Application No: AB/52/21/PL

Site Address: Old Bank House 3 High Street Arundel BN18 9AD

Description of works: Replacement of all windows with new timber double glazed sliding box sash windows and the proposed rendering of the South Elevation (front) with render painted white. This application affects the setting of a Listed Building and the character and appearance of the Arundel Conservation area.

EXISTING SOUTH ELEVATION
(1:100)

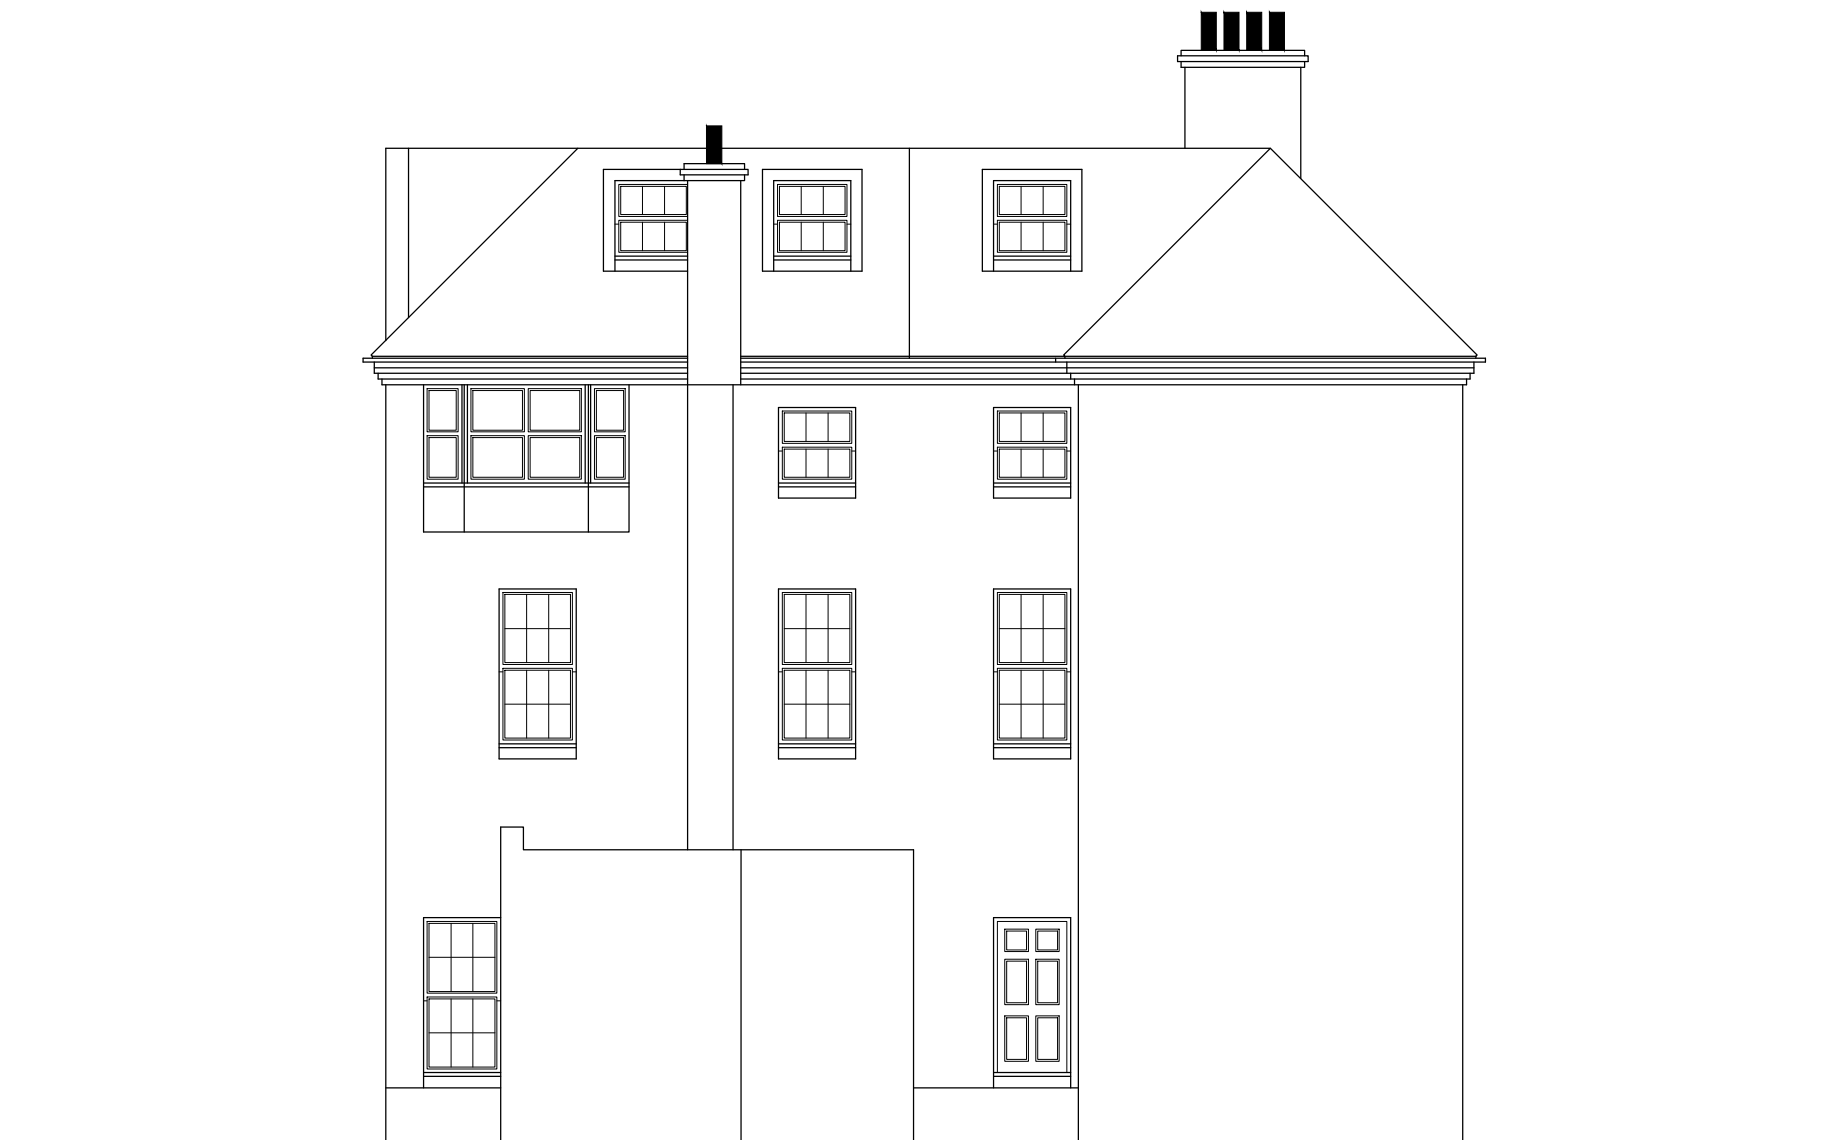
In respect of the proposal to render the south elevation of the building it is considered that historical information should be submitted by the Agent to warrant what will be a material change in its prominent street facade. If the Council consider it acceptable to render the facade then the work needs to be undertaken in accordance with best historic building practice. A comprehensive and acceptable method statement is required which should include details such as mortar mixture, method of application and finish, depth, and how existing details such as the existing brick dentil course at eaves level, for instance, will be treated.
